**Consultation Response from Alan Smith,  
KC Waste Strategy (Refuse & Recycling)**

**2025/92443 Huddersfield Open Market, Brook Street, Huddersfield, HD1 1DY**

**Responding Ref: WPS 25 062**

01 LEVEL 00 PLAN
1:100

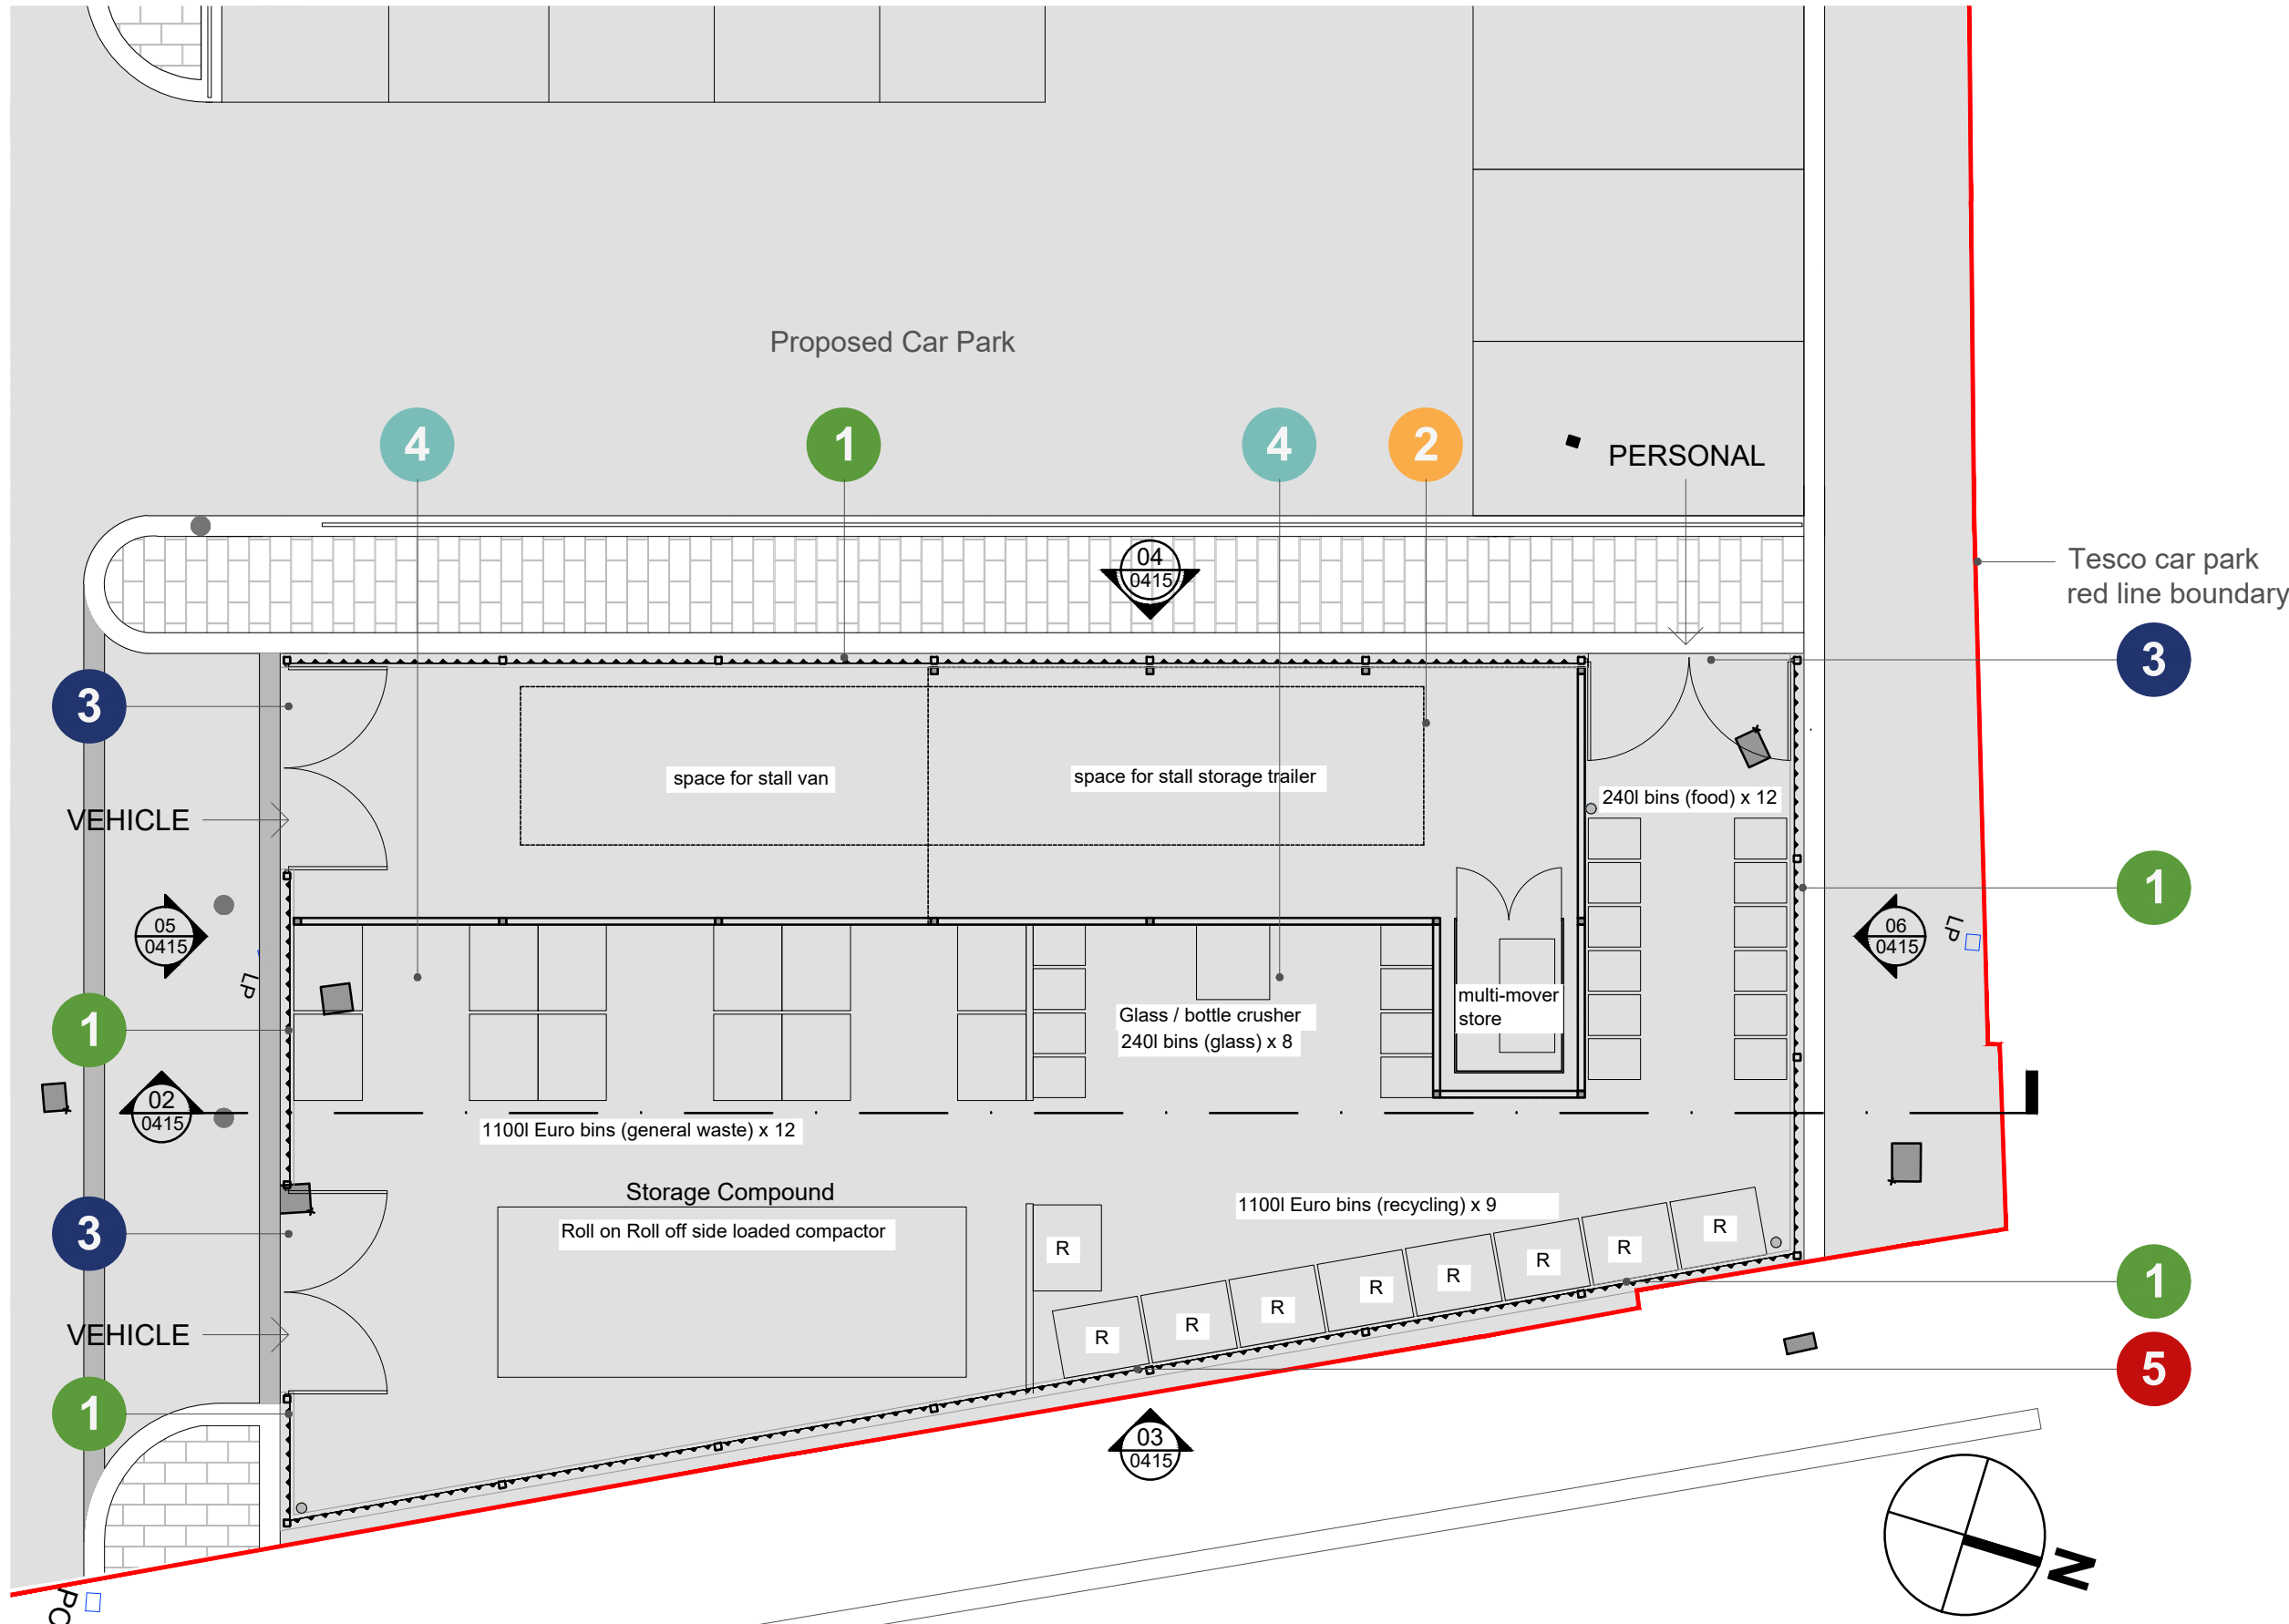
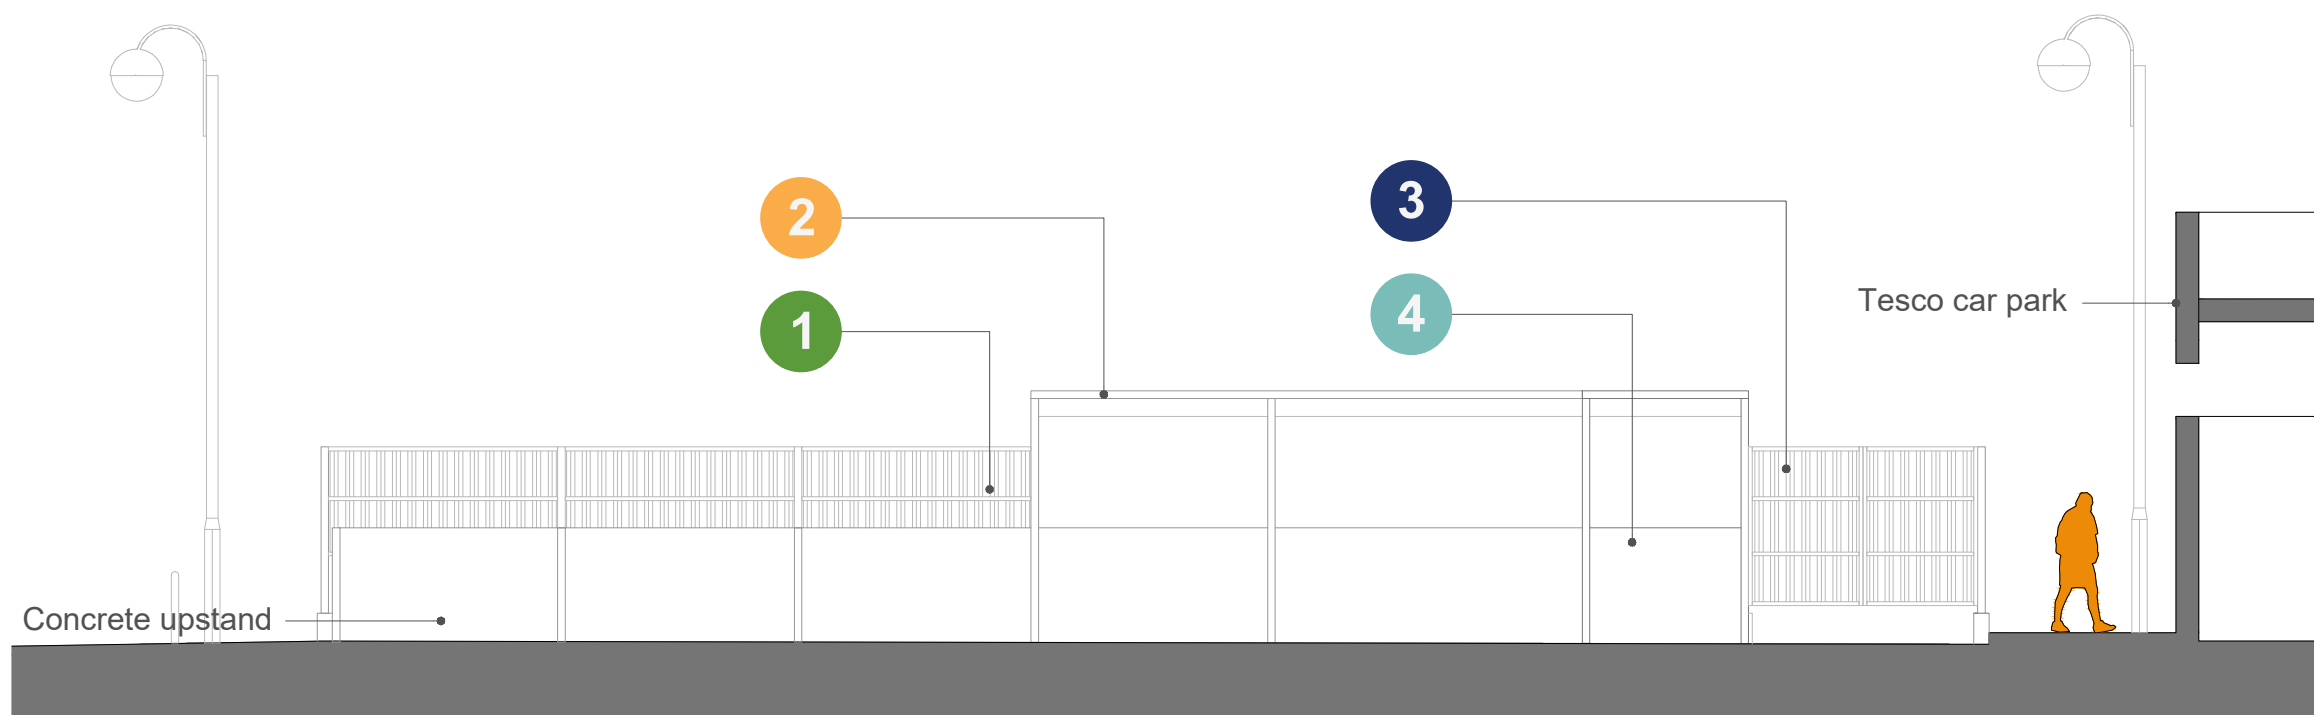
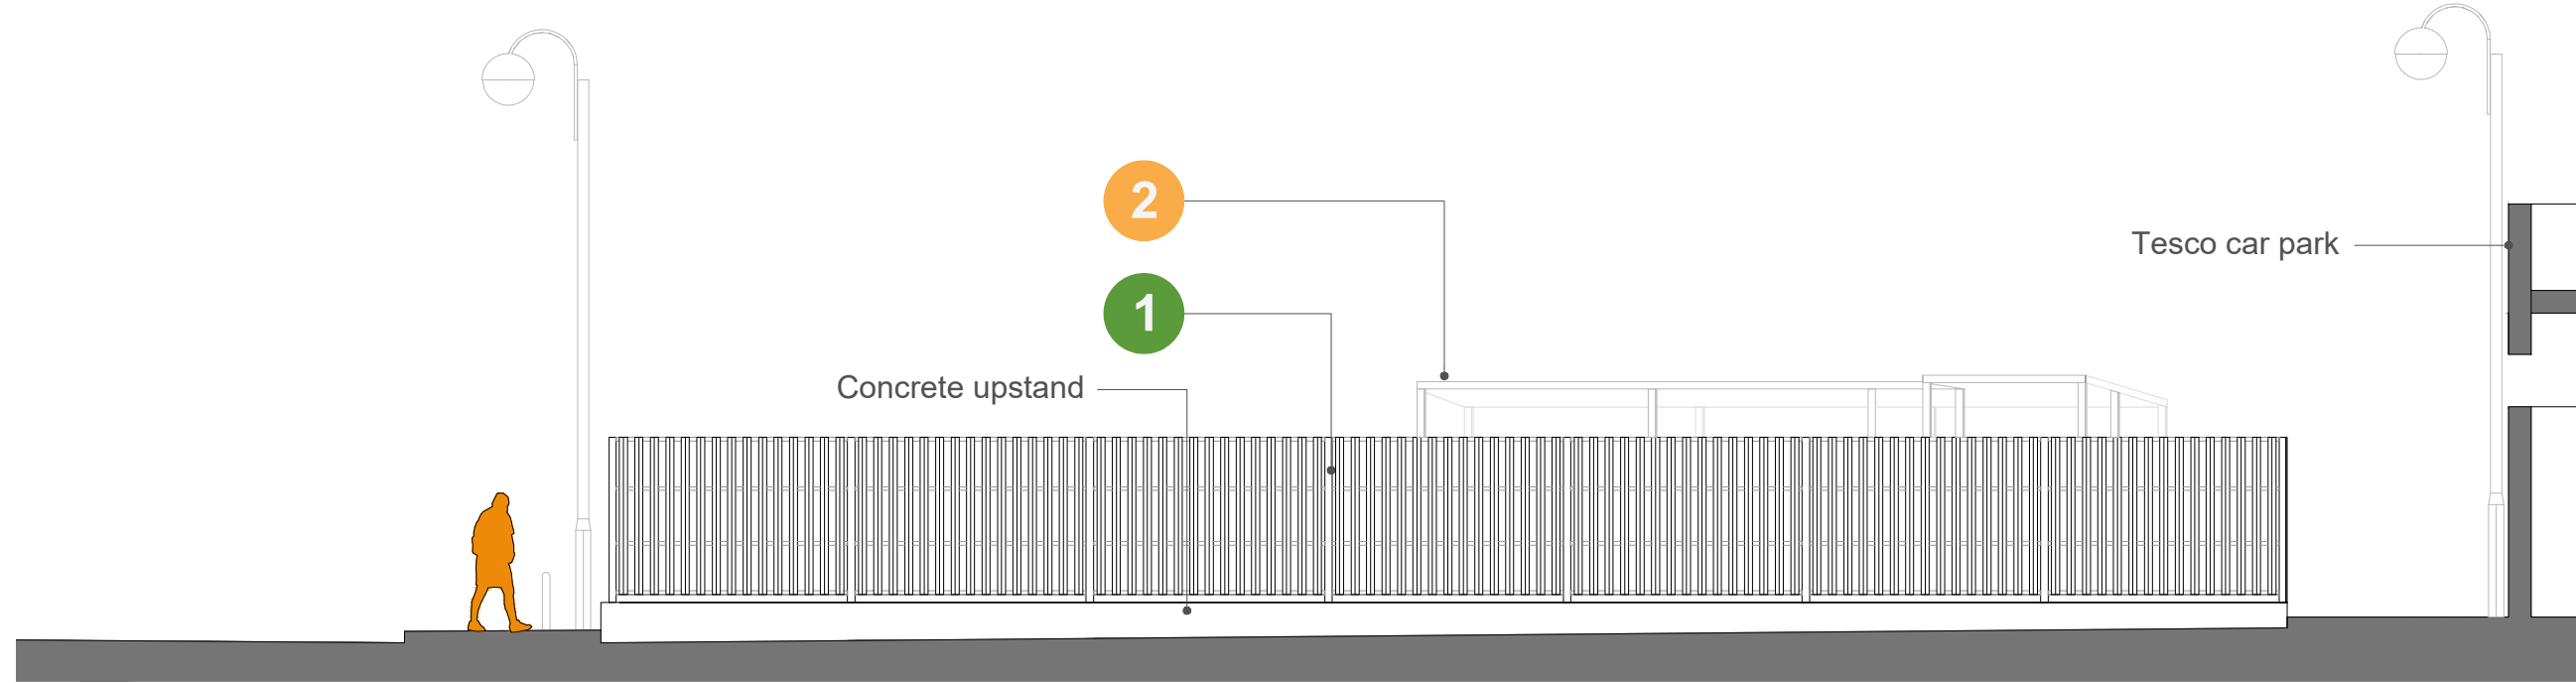
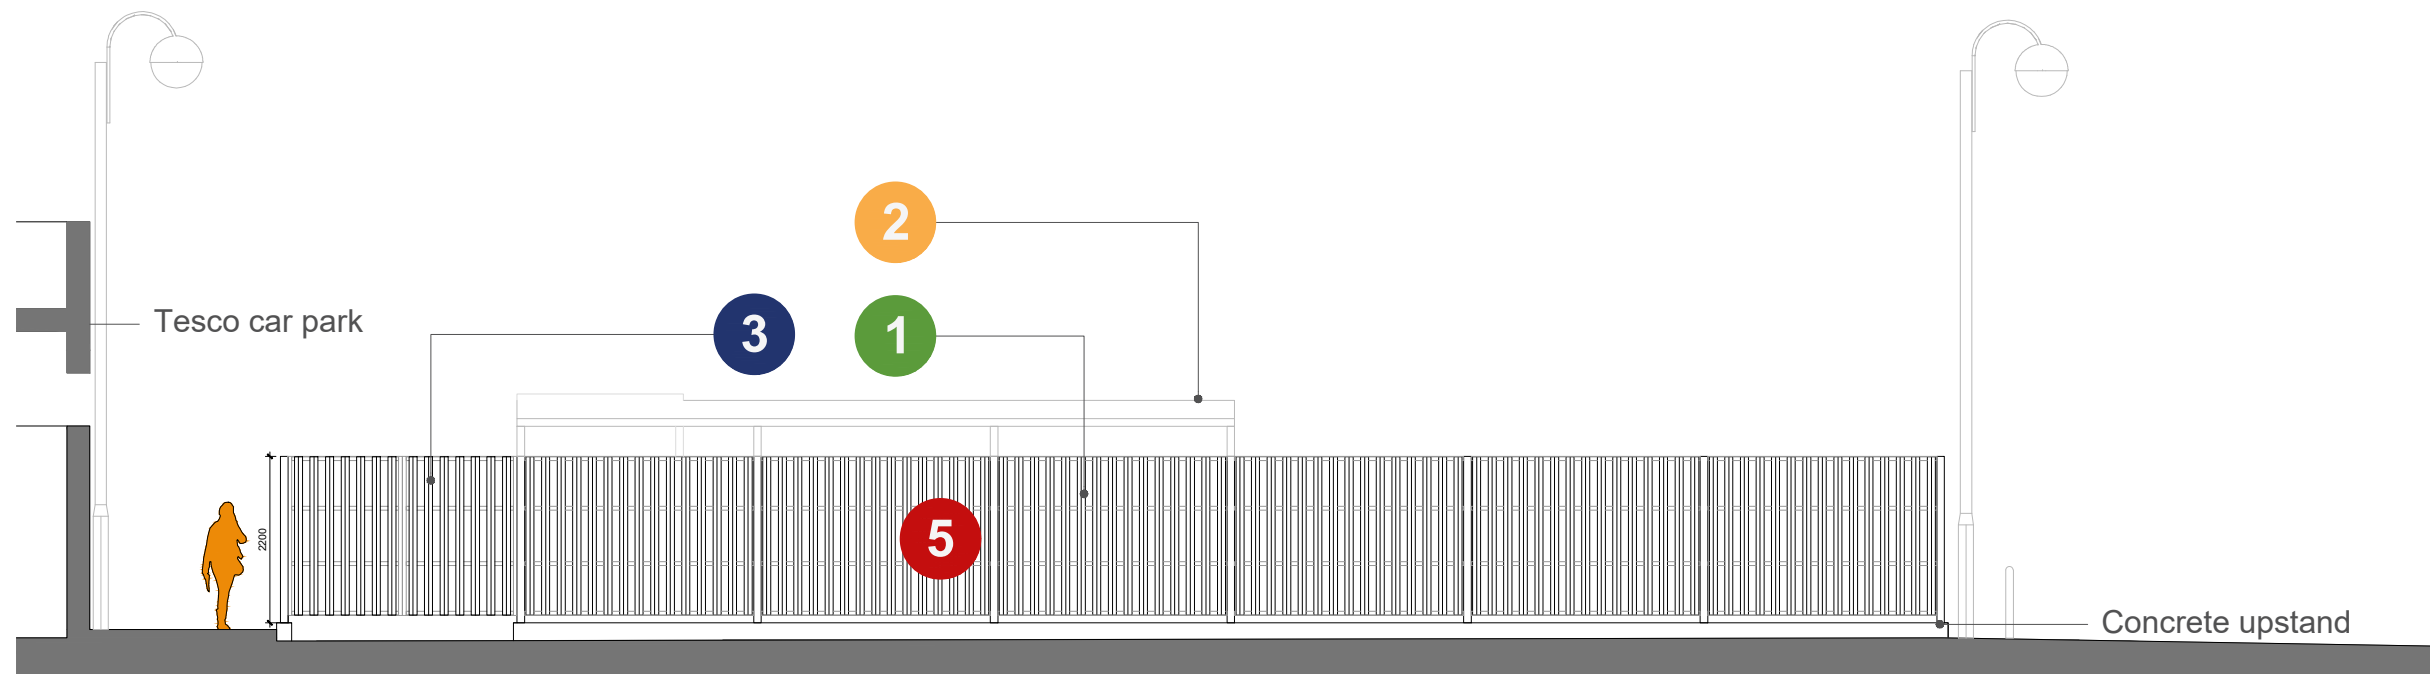
The applicant has submitted a drawing, “*General Arrangement - Storage Compound Plan, Elevations and Sections as Proposed, Dwg No. HMH-GSA-WC-XX-D-A-0415, Rev P02*”.

Further to my comments dated 13<sup>th</sup> October 2025, which still apply to this new submission, the design for the waste compound has changed, as shown below.

An update would be welcomed of the Waste Management Strategy in Section 4.8 of the ‘Access and Building Strategies’ to confirm that the new proposal is acceptable to the WCA.
